TO:	Arun District Council FAO: Amber Willard
FROM:	WSSC – Highway Authority
DATE:	9 February 2026
LOCATION:	Land East Of The Croft Surgery Barnham Road Eastergate PO20 3RP
SUBJECT:	BN/10/26/PL Approval of details reserved by condition under BN/38/24/PL relating to conditions 5, 7, 16, 19, 20, 21, 22, 23 & 24.
DATE OF SITE VISIT:	n/a (desktop study undertaken)
RECOMMENDATION:	More Information Required

Comments below specifically respond to highways-related condition 16 (secure and covered cycle parking).

Description:
EXTERNAL WORKS Sh12

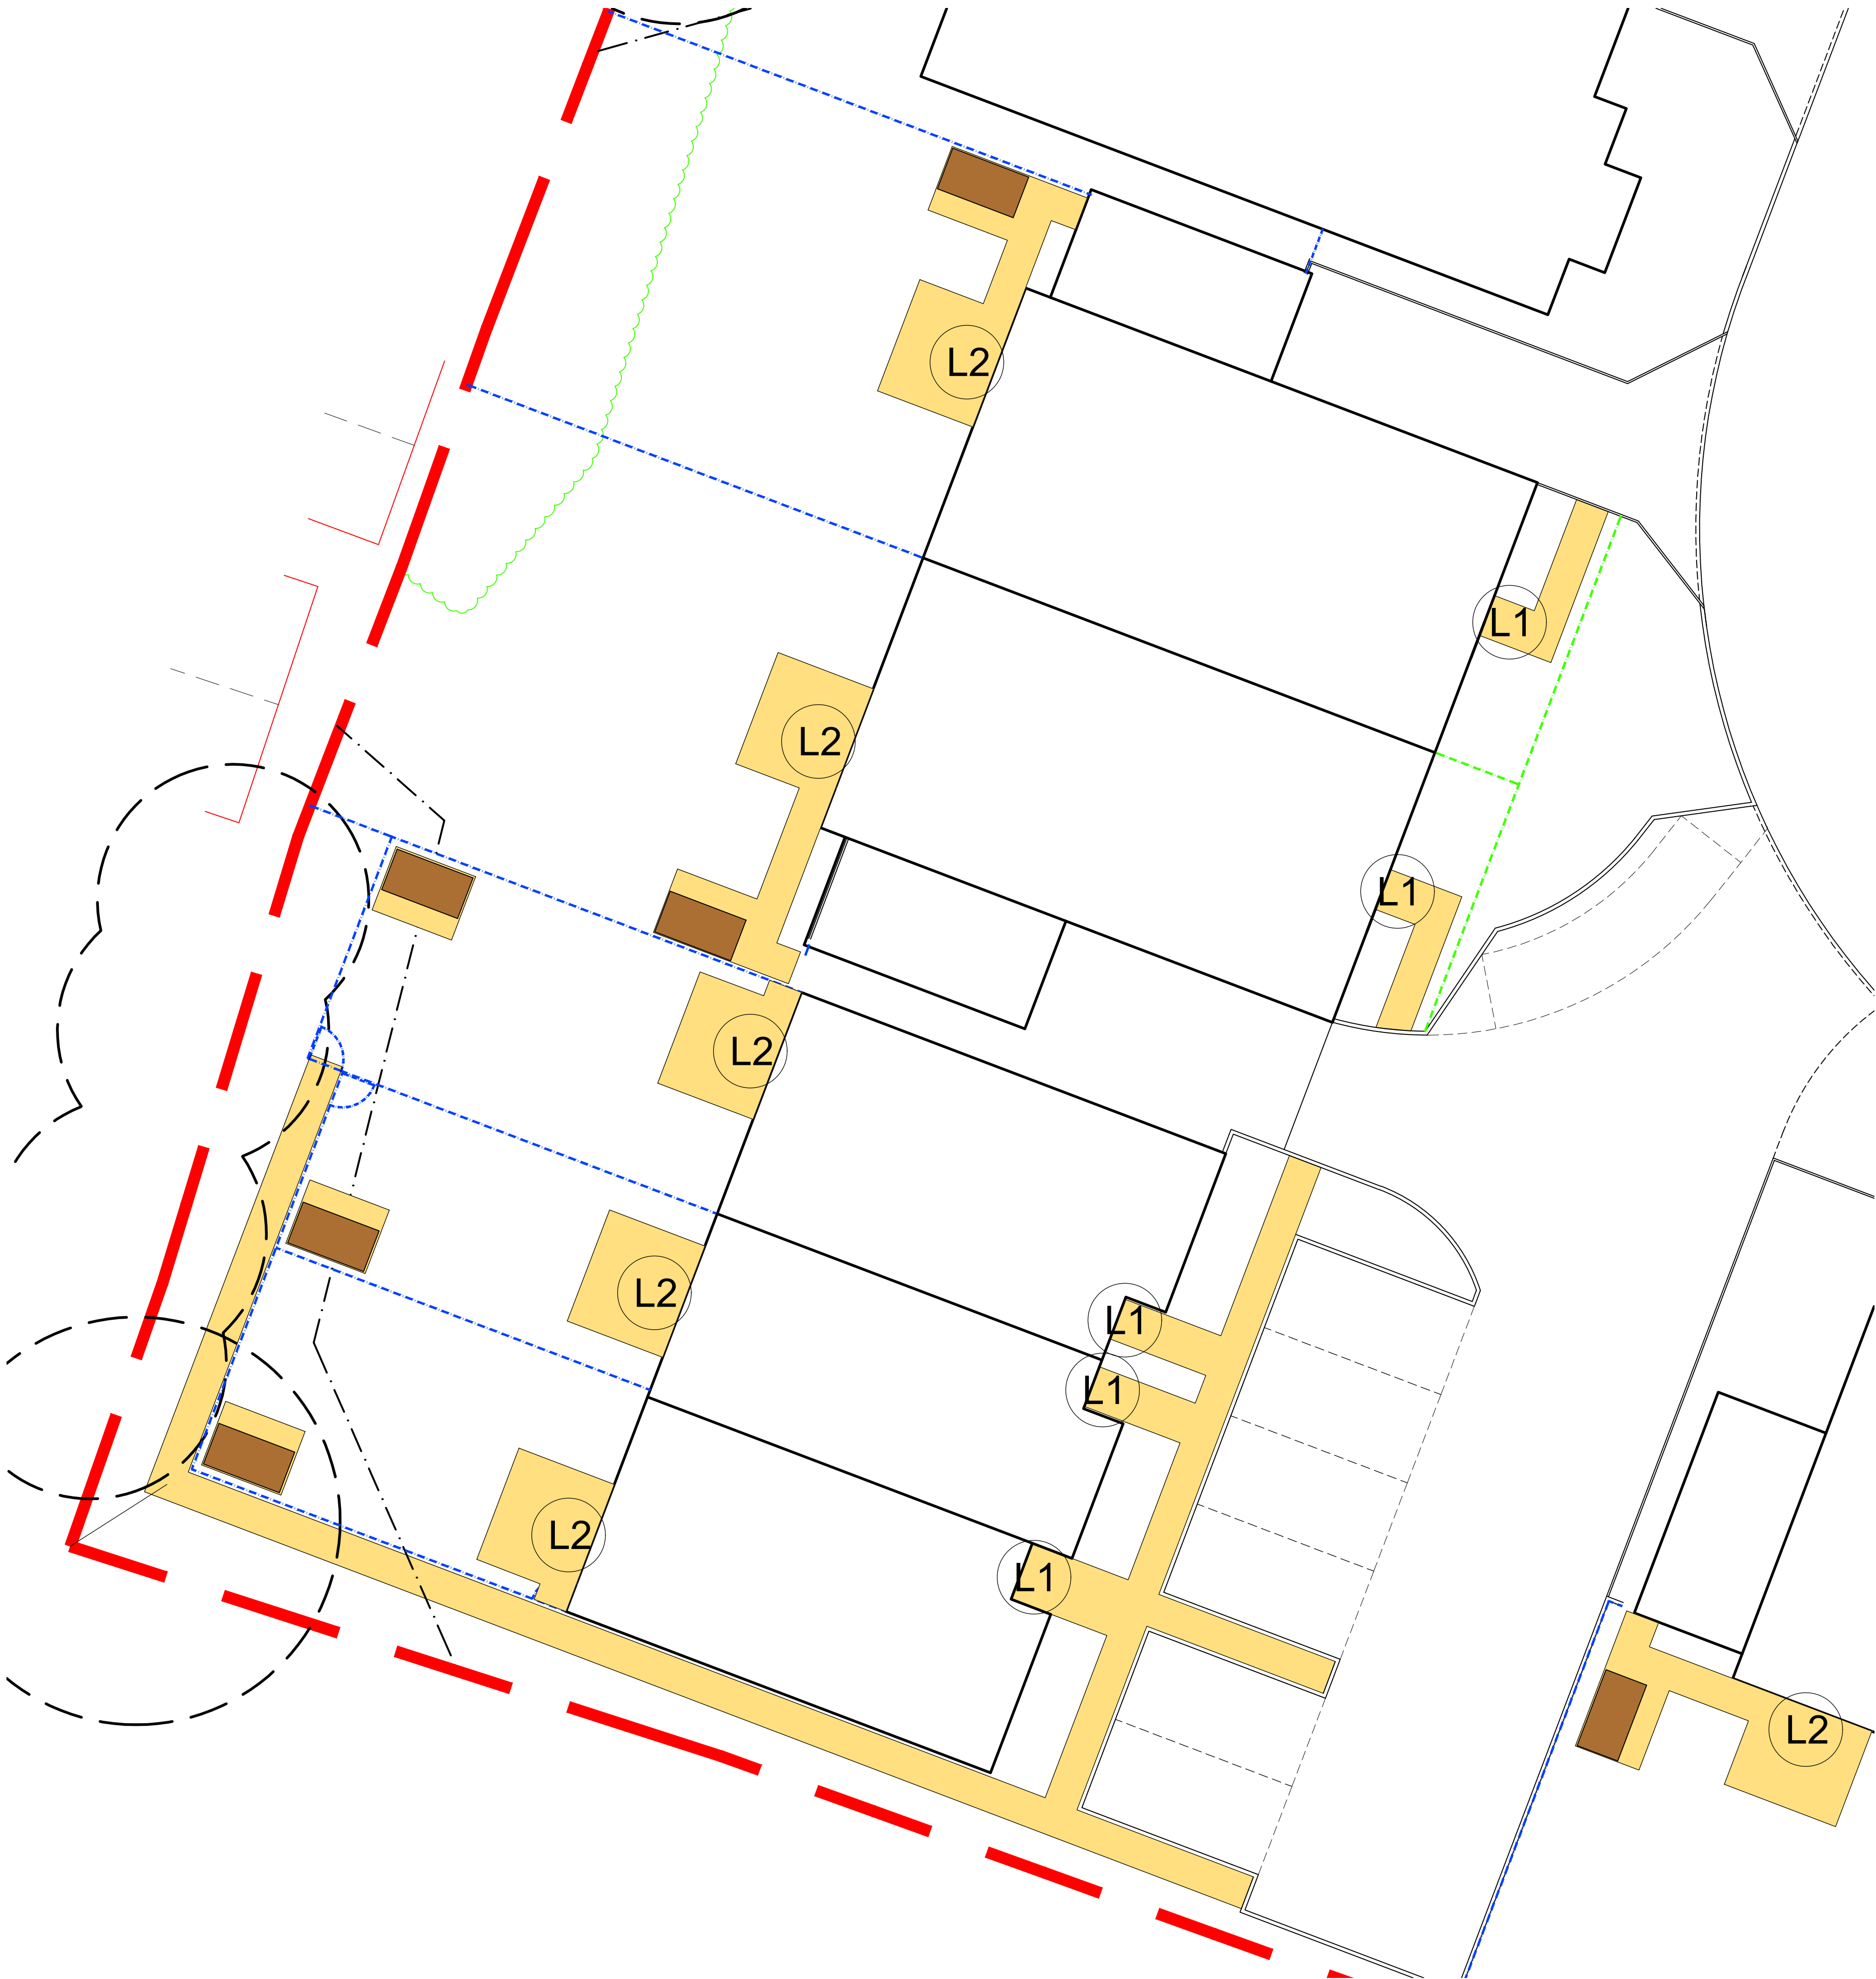
- (1) The following extracts, taken from the external works plans, show the plots where it is not clear how access to the bicycle storage will be achieved from the access road. Applicant to provide details, please.

(2) And for the following (overleaf), no cycle storage is shown. Applicant to amend, please.
